Rezoning Transportation Analysis
Petition Number: Insert Zoning Petition #2021-257
General Location Identifier: 11306113

Date	Description
04-18-2022	First Review (KP)

Transportation Summary

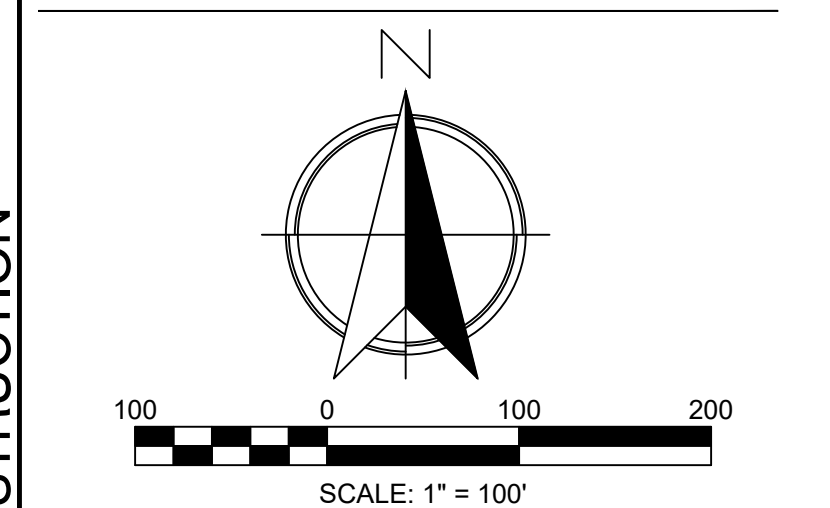
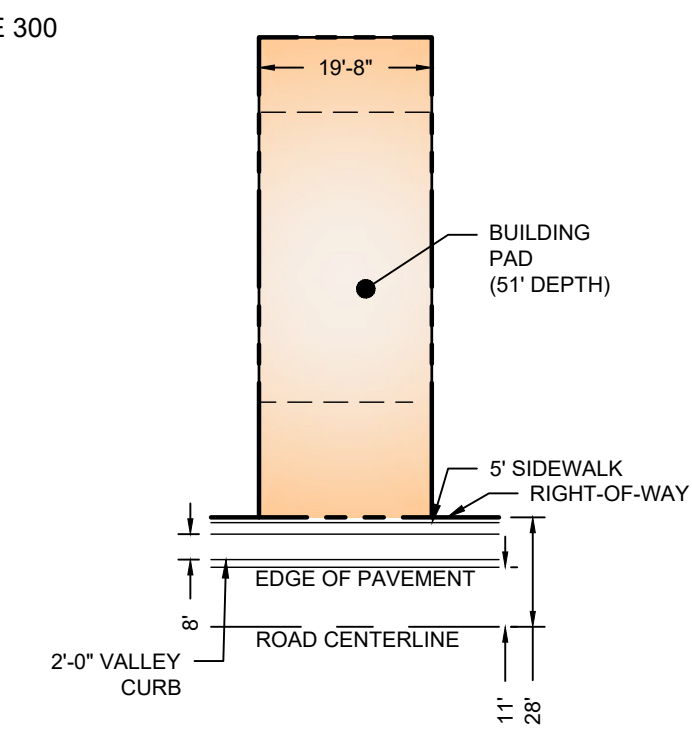
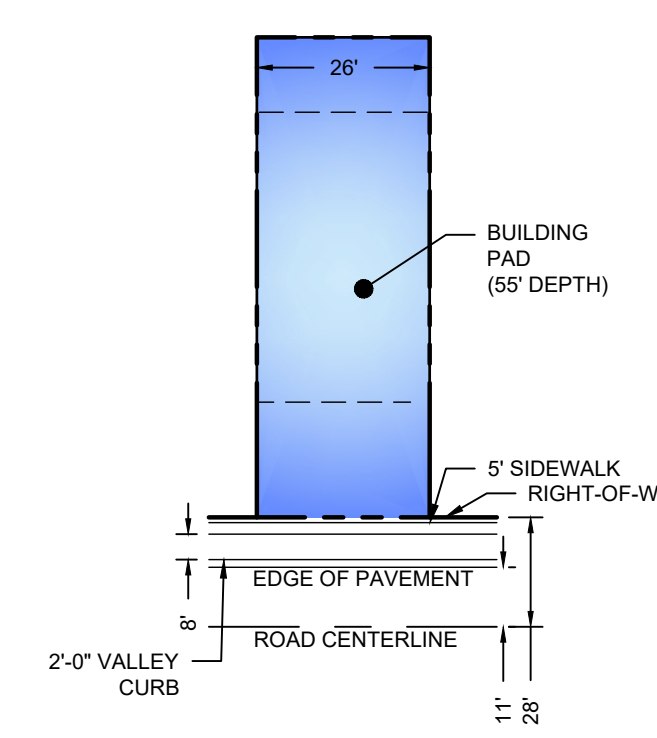
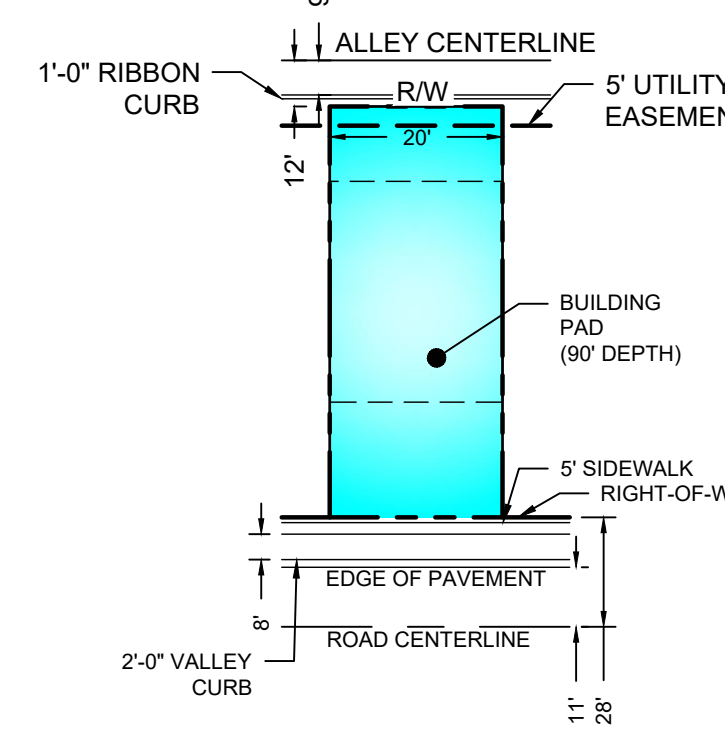
1. Curb line:

- a. **Amos Smith Road:** Label and dimension the existing back of curb from the existing road centerline.
- b. **Old Dowd Road:** Revise the site plan and conditional notes to commit to construct the curb line measured from 27-feet from the existing road centerline to the back of curb.

Label and dimension the curb and gutter from the centerline for each road on the site plan.

Revise the site plan and conditional notes by incorporating the suggested roadway improvements from the approved TIS.

3. Right-of-Way:

- a. **Amos Smith Road:** Revise site plan by labeling and dimension the right-of-way from the existing road centerline.
- b. **Old Dowd Road:** Revise the site plan and conditional note(s) to commit to dedicate 35-feet of right-of-way from the existing road centerline.

4. Revise site plan and conditional note(s) to commit to construct an 8-foot planting strip, and 8-foot sidewalk along the site's frontage of Old Dowd Road. Additionally, revise the site plan and conditional notes to commit to construct an 8-foot planting strip and 6-foot sidewalk along Amos Smith Road and each internal public street. The site plan shall label and dimension both items from the back of curb and gutter on each public street.

5. Revise the site plan and conditional notes by labeling each public street and including the relative CLDSM USDG cross section each street will be constructed in accordance with. Additionally, please label and dimension the right-of-way and public access easements for each public street.

- 6. Revise the site plan and conditional notes to commit to construct an 8-foot buffered bike lane along the site's frontage of Old Down Road. The site plan shall label and dimension the bike lane.
- 7. A site plan note(s) specifying dedication and fee simple conveyance of all rights-of-way to NCDOT before the site's first building certificate of occupancy is issued as needed.
- 8. A site plan note specifying that all transportation improvements will be approved and constructed before the site's first building certificate of occupancy is issued as needed. The petitioner may phase transportation improvements if said improvements and phasing are explicitly described in site plan notes.
- 9. Revise the site plan and conditional notes to commit to provide a street stub, in accordance with CLDSM standards, to the northwest property boundary.

- 10. Revise the site plan and conditional notes to commit extend the proposed street and provide a street stub with a temporary turnaround, in accordance with CLDSM standards, at the southeast property boundary.

- 11. Revise the site plan and conditional notes to commit to provide a 100-foot protected driveway stem at the site's access from Old Dowd Road.
